**Response to Peer Review Comments dated February 7, 2018**  
**Maine Medical Center, East Tower and Visitor Parking**

We are writing to provide supplemental information and respond to review comments presented in a memorandum From Wright Pierce Engineers dated February 7, 2018 regarding the above referenced applications.

SHEET 6
SHEET 7 SHEET 8

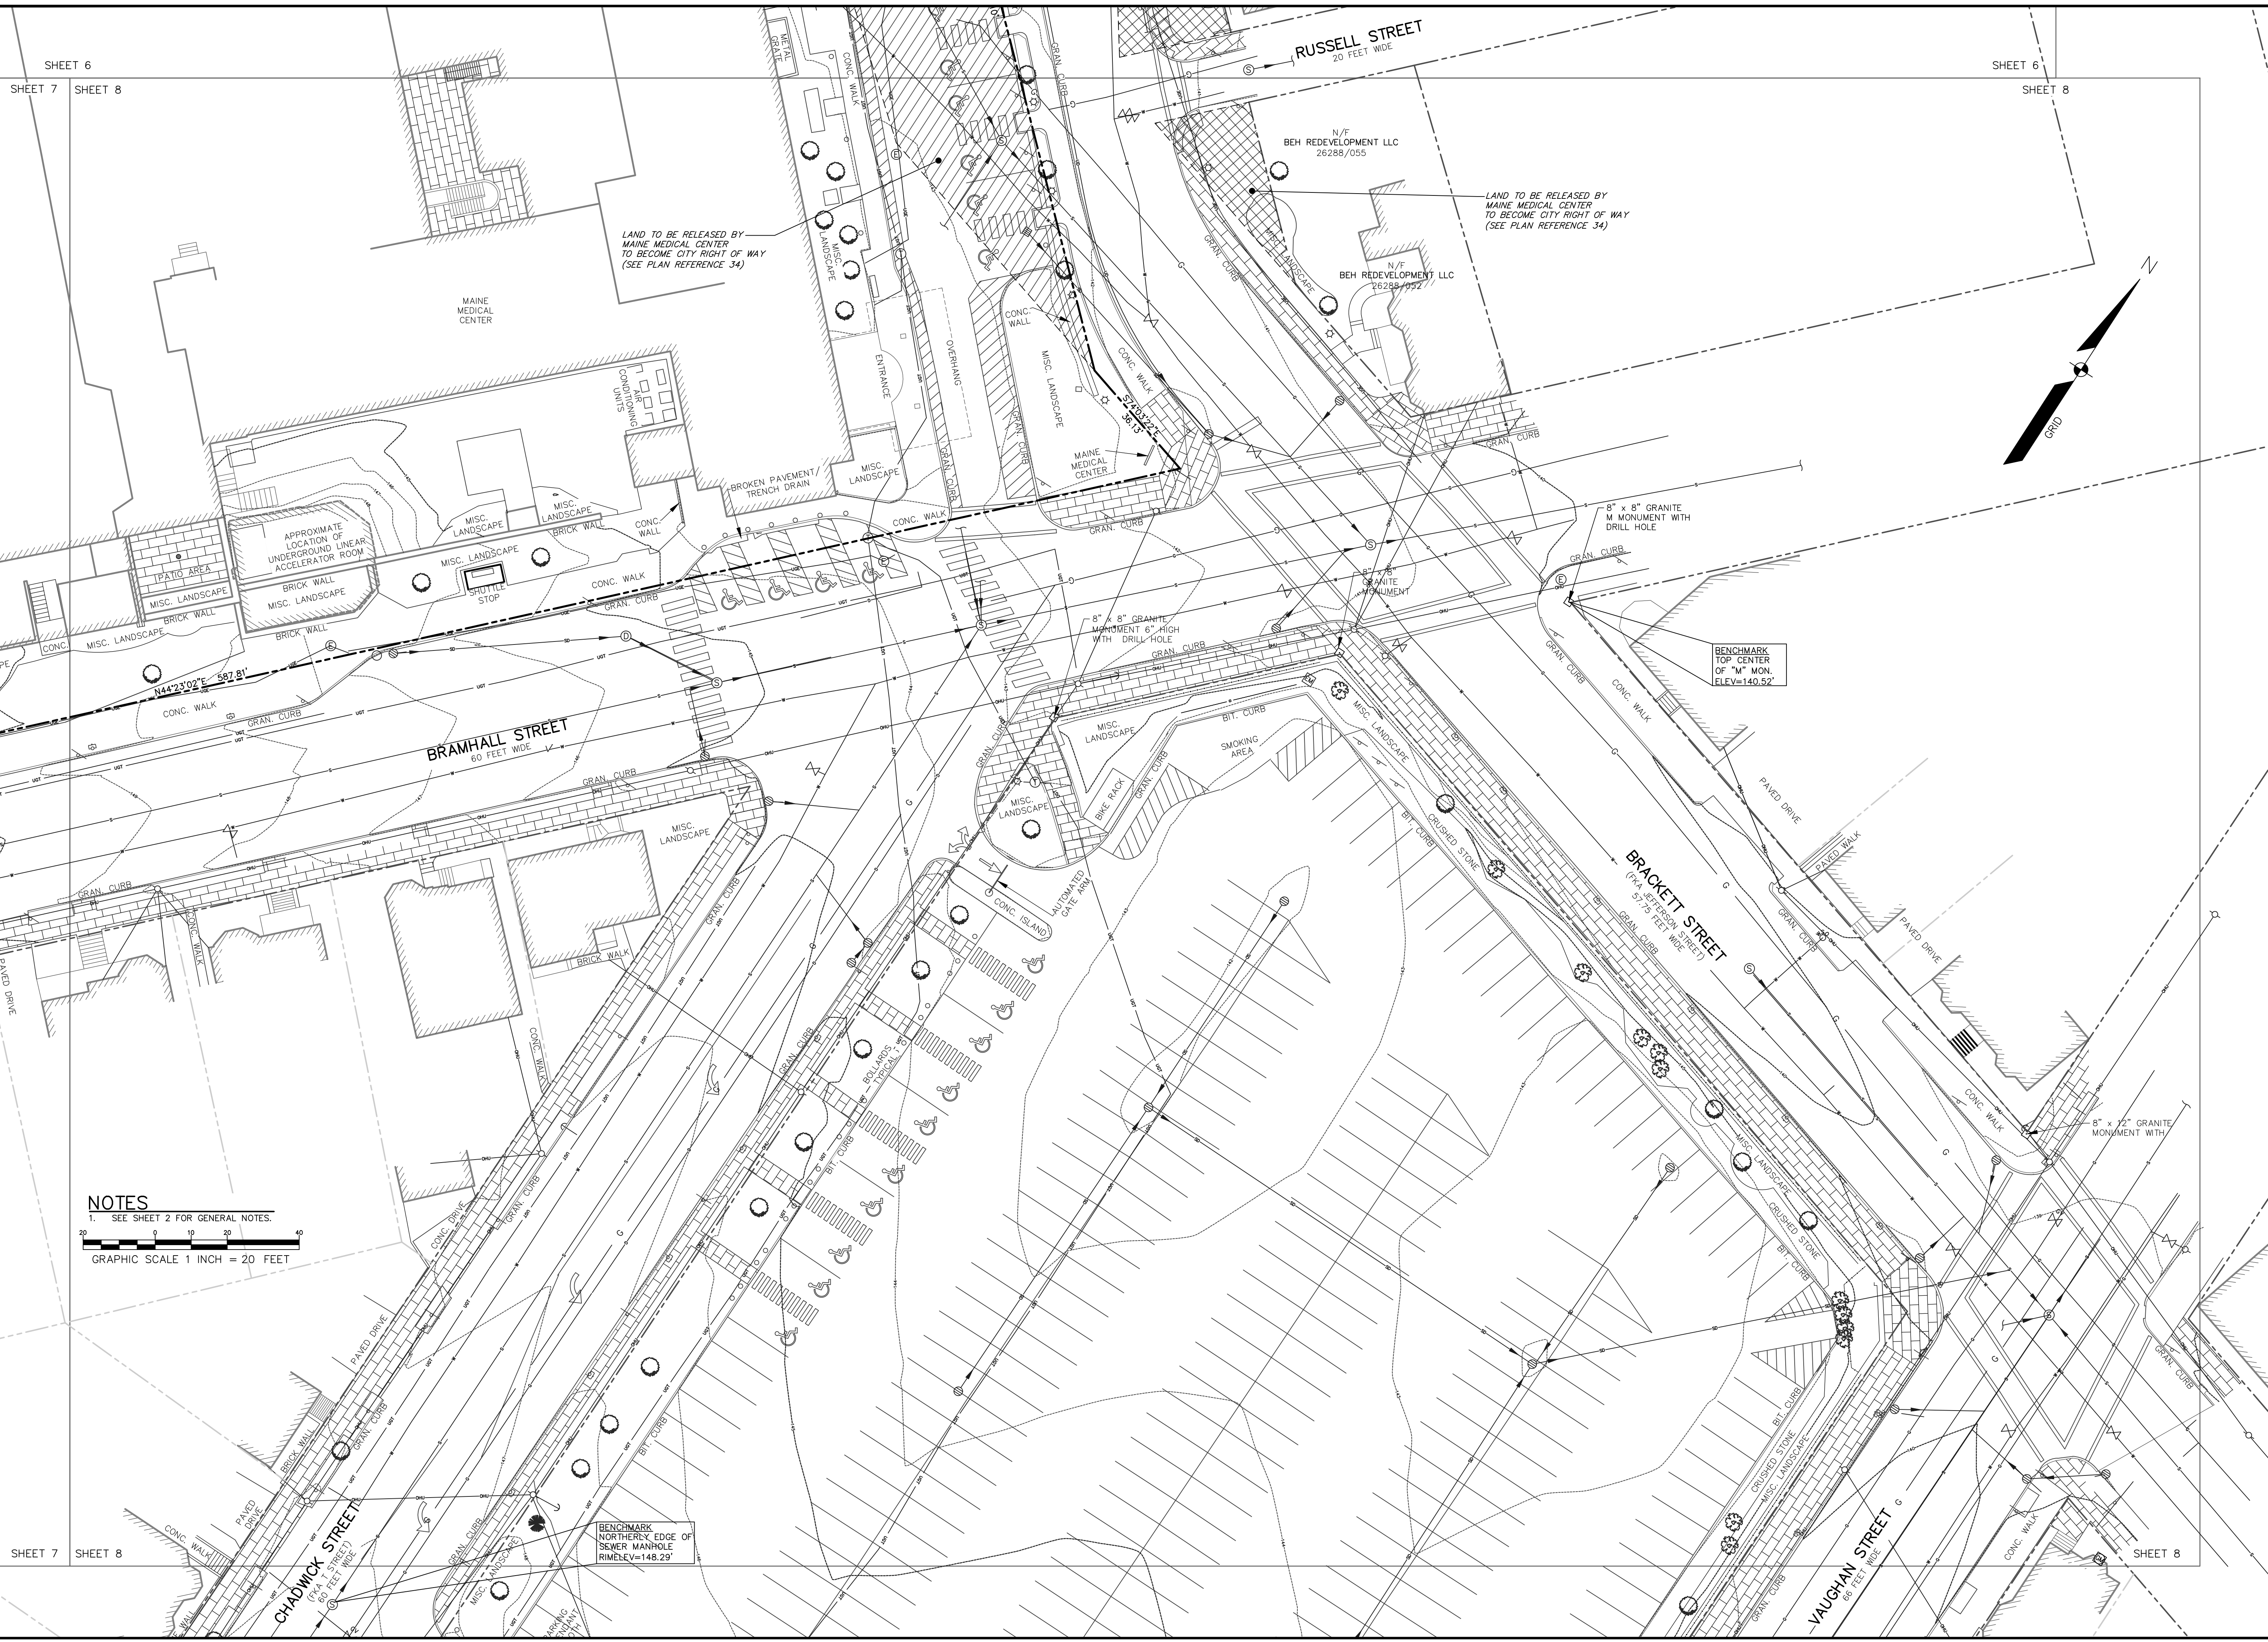
*ii) Plan 2D Boundary Survey indicates a connection or stub connection leading from the catch basin on the south side of the Visitor Garage that may allow for connection from the Visitor Garage roof drain into the separate storm drain system. The applicant shall provide the following:*

*(1) An updated boundary survey in the vicinity of "Plan 2D Boundary Survey" with utility elevations, pipe sizes, and pipe materials in accordance with the City's Chapter 14 and Technical Manual requirements for a Boundary Survey. Anecdotal information regarding the difficulty for construction in this corridor was discussed in the February 1 meeting. However, a sewer pipe crossing currently exists in this corridor, as does a storm drain or storm drain stub. City staff need additional information regarding existing utilities to confirm if a connection to the separate storm drain will be feasible or not.*

A revised boundary survey plan with structures labels as well as rim and invert elevations has been submitted separately.

The staff comments note a drainage stub as a potential connection. We understand this to be a reference to the line shown projecting to the northeast from structure CB#22087 (CB-112). We

have investigated this opening in the manhole. This is not a drain stub that extends as far as the survey plan implies. This line represents the location of a temporary sewer pipe stub that was cored into the structure during the 2004-2007 construction as temporary means to convey a former sewer in this location to Gilman Street, while the Visitor Garage and the permanent sewer was under construction.

It appears that this opening is generally oriented toward the adjacent sewer manhole. The stub was cut and capped and sealed close to the structure after construction and prior to the installation of the adjacent sewer manhole, electrical manholes and duct banks. We believe that access to this entrance into the manhole is now obstructed by these other structures. Due to the tight clearances of the subsurface utilities in this area, excavations were backfilled with flow able concrete fill in this area.
